Project Name **SOUTHWEST GASTROENTEROLOGY**

1. **Project # 1004909**
06DRB-00930 Major- SiteDev Plan BldPermit

DEVELOPMENT REVIEW BOARD – SPEED MEMO

CITY OF ALBUQUERQUE
PLANNING DEPARTMENT
DEVELOPMENT REVIEW BOARD

SHEET TITLE:
DEVELOPMENT REVIEW BOARD
SITE PAVING PLAN

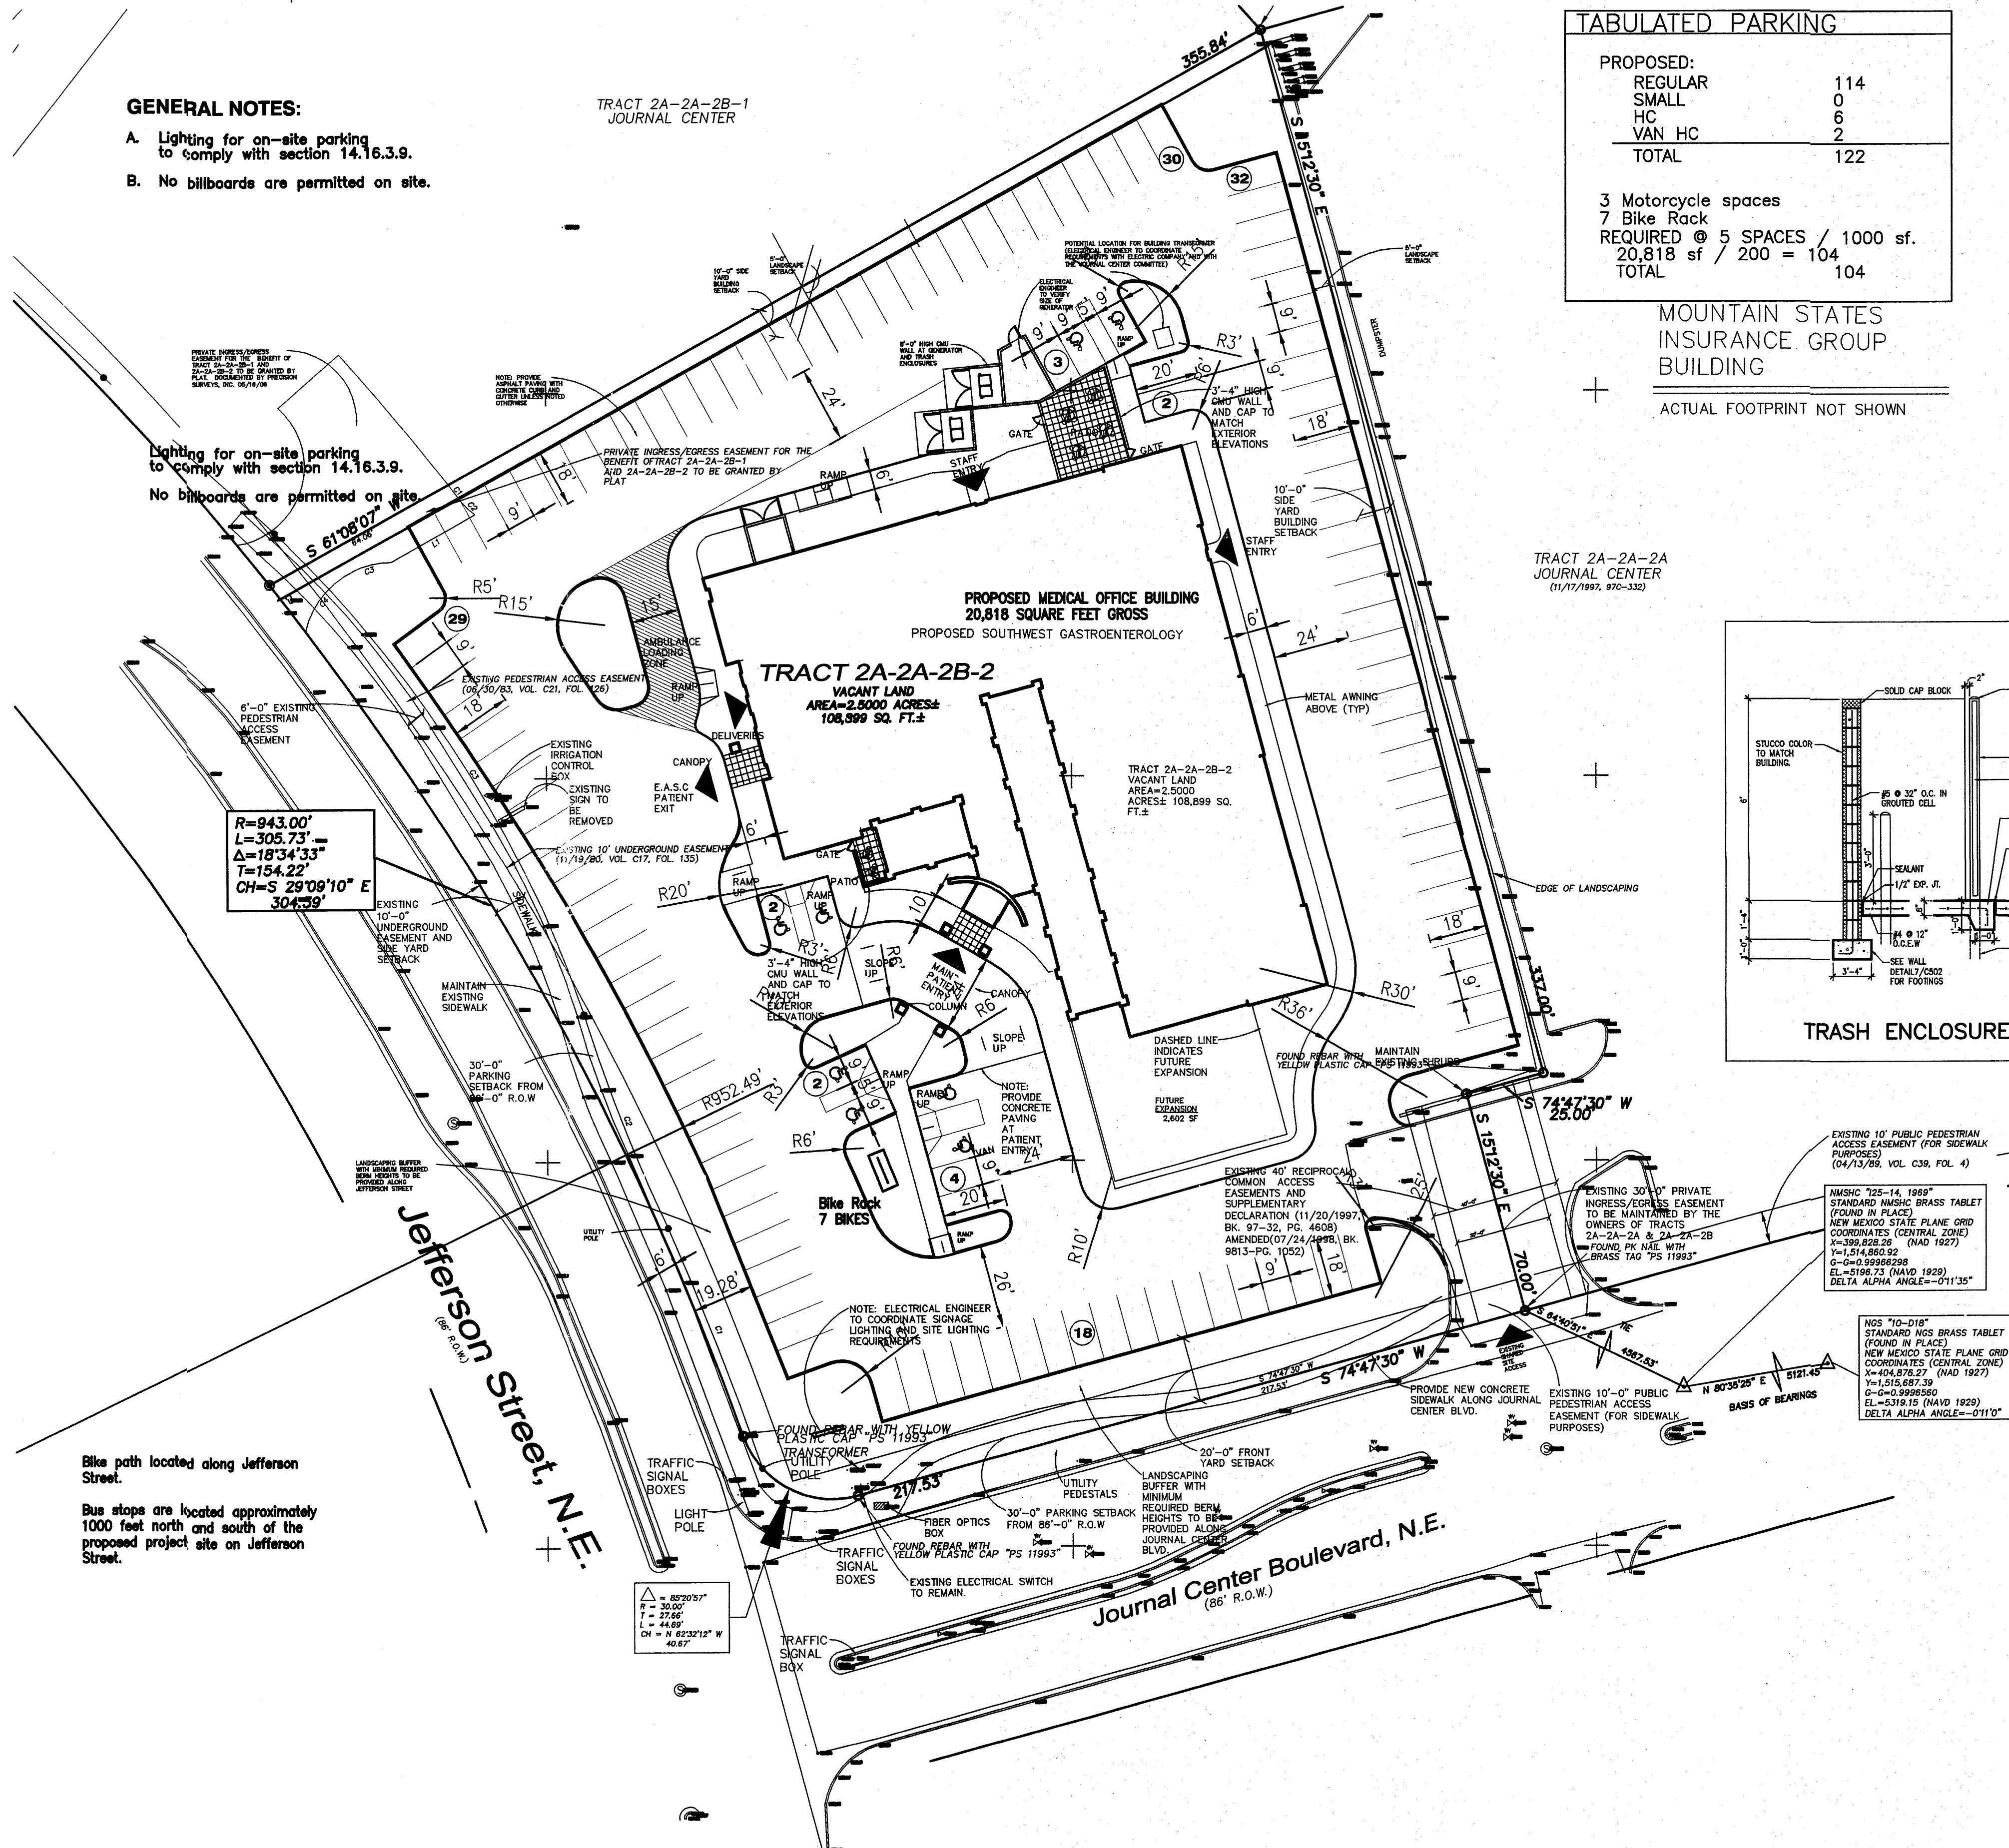
Are there ADA ramps at the entrance on Journal Center Blvd? What are the radii values? What is the aisle width on the west side? There is no x-access easement on the NW corner. Are the sidewalks in place? The plat needs to show the pedestrian easements for the meandering sidewalks. Need to check with building permits regarding the use of ramps within the parking stalls. Any pedestrian connections from Jefferson? The site plan is full of notes that cannot be read.

The title of the site plan sheet A-1 should read "Site Development Plan for Building Permit". Please remove the first paragraph in the signature block that refers to EPC approval. This site plan should not have gone to EPC for approval. Also, the word "signoff" should be taken out of the signature block title. DRB is not signing off on an EPC approved plan which is what "signoff" refers to in this case.

The property lines are not clearly identified on the site plan as required.

Without keyed notes, the elements required on the SPBP Checklist are difficult to find. As far as easements are concerned, only the easements are needed, not the location of fiber optics box, Traffic signal boxes , etc.

The site plan is too busy. The required checklist elements are even harder to find without keyed notes & a busy site plan sheet.

Please clean up the site plan sheet, add keyed notes for those items on the SPBP Checklist...signs, lights, refuse enclosure, etc. Then re-submit one copy to Planning by Monday, July 24th in time for us to review.

L101

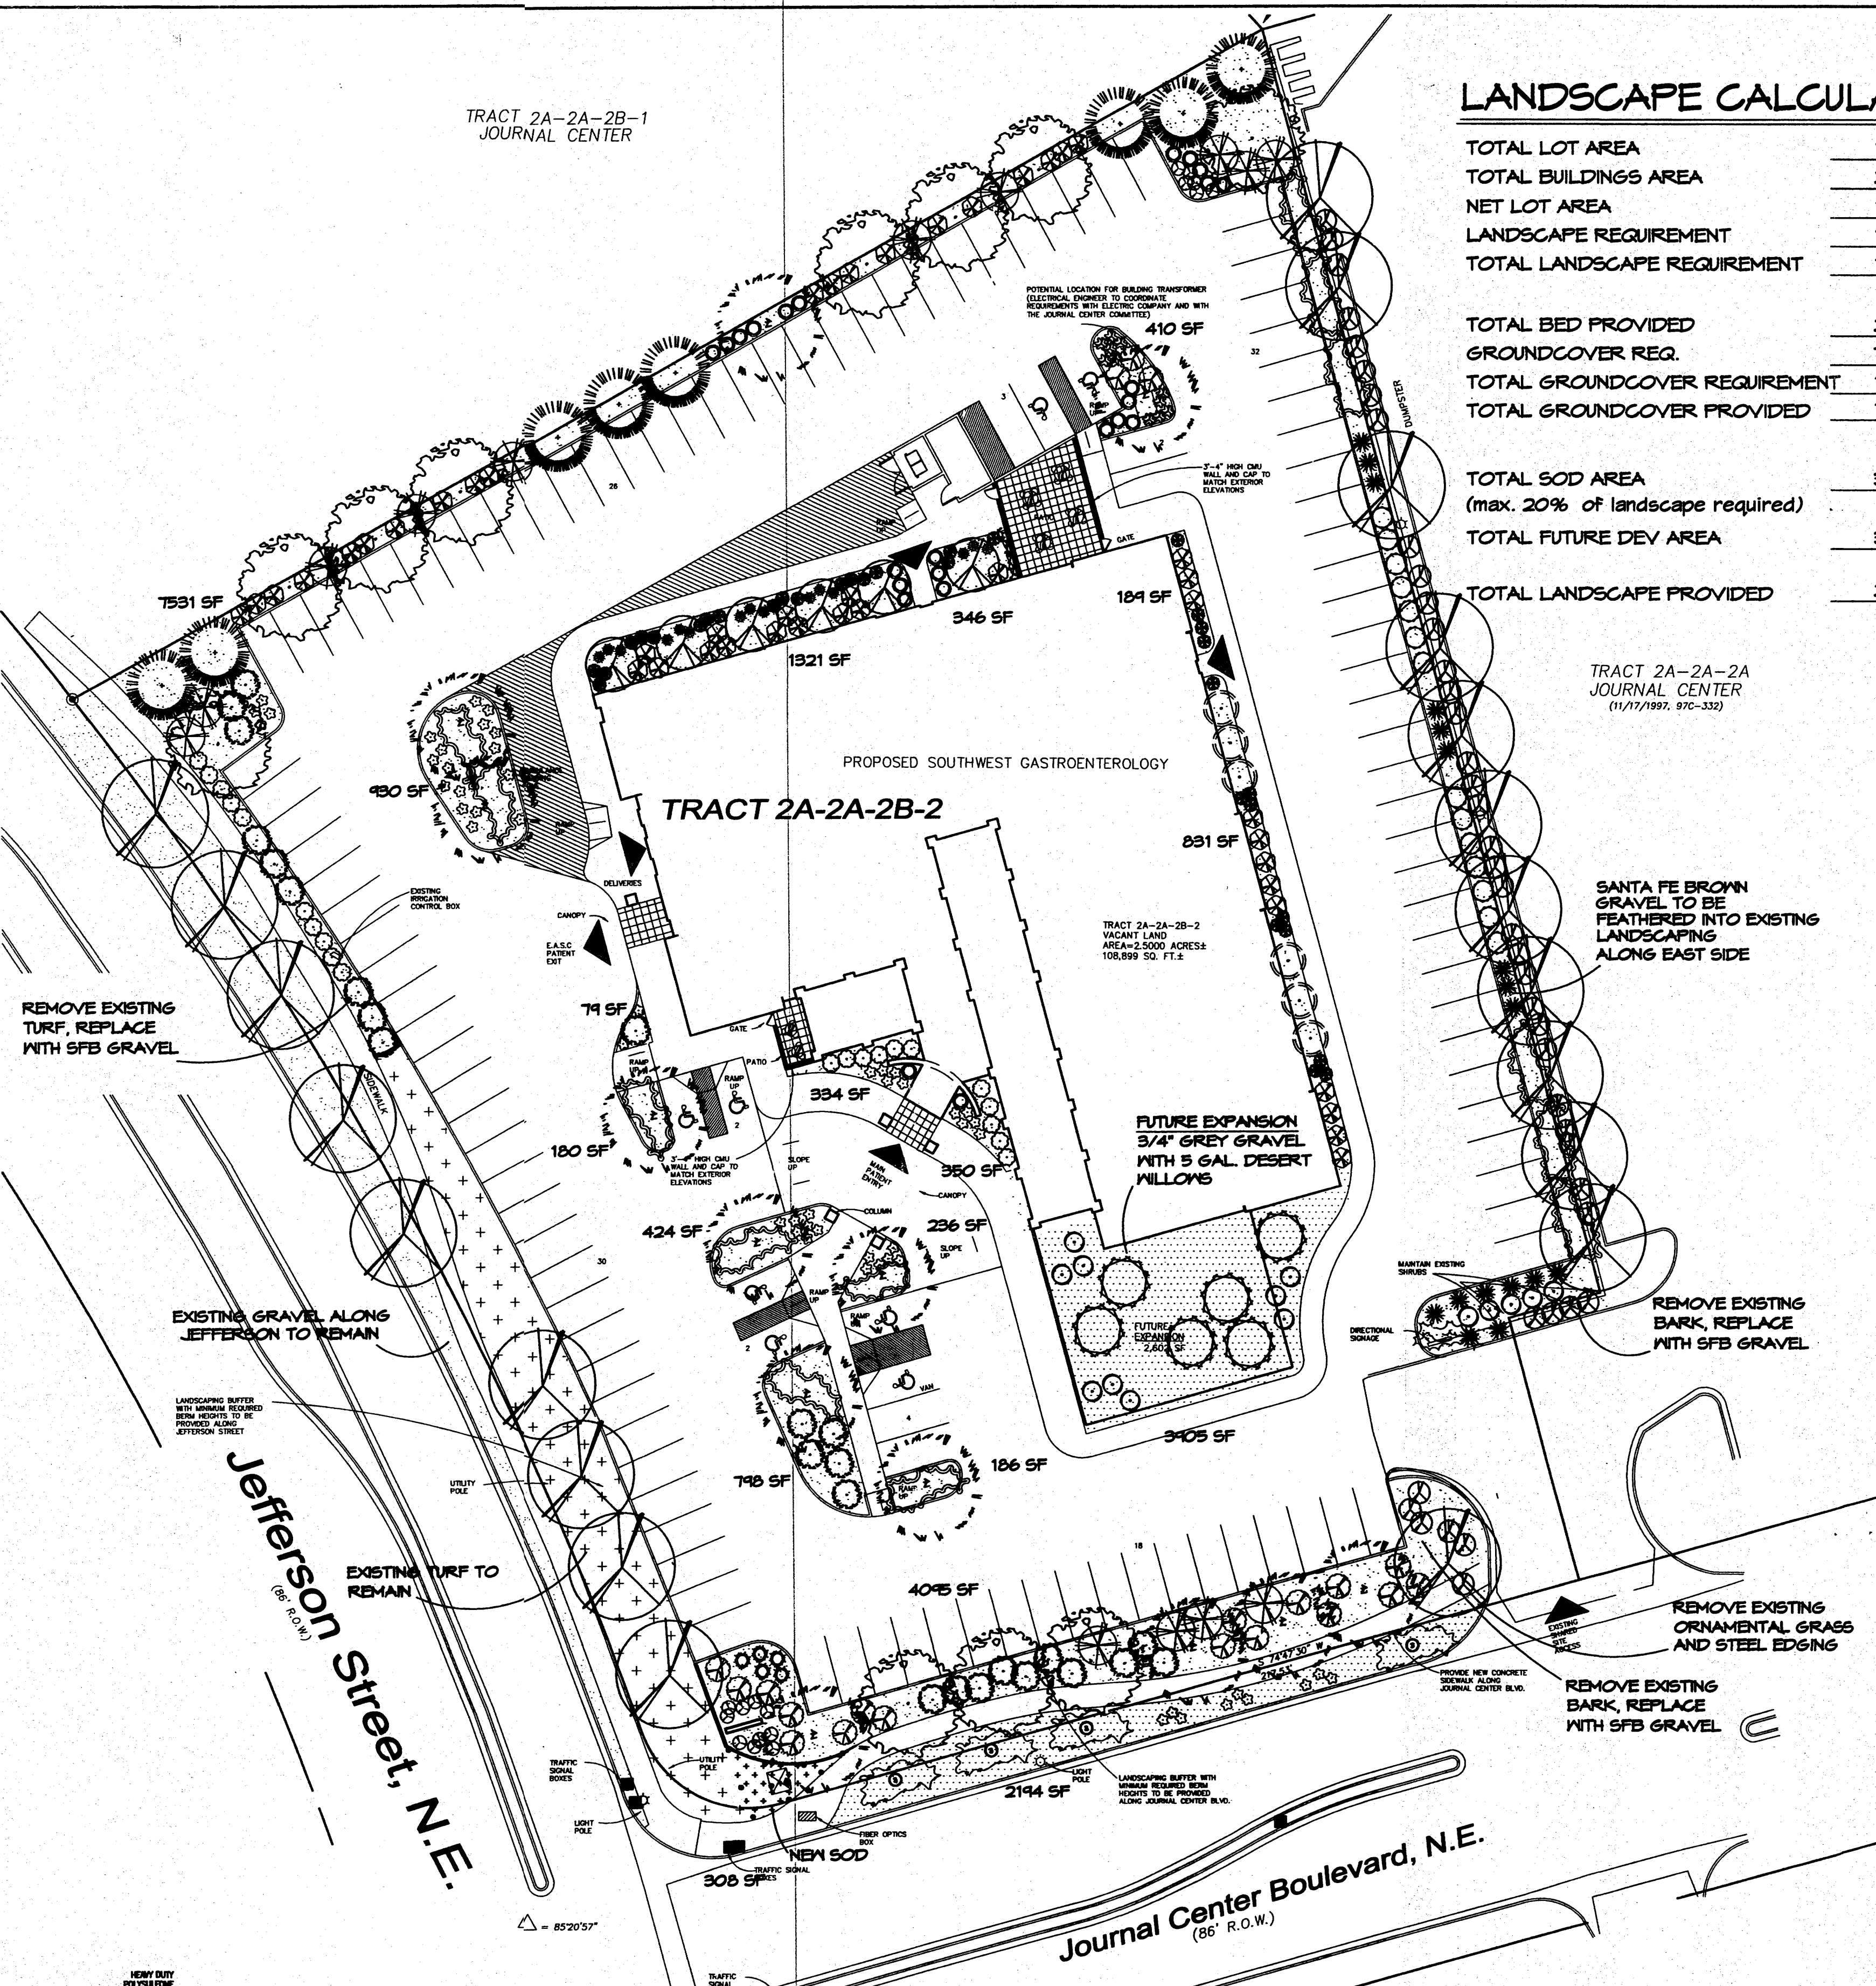
The ¾" grey gravel should have a minimum depth of 3" specified on the Landscape Plan.
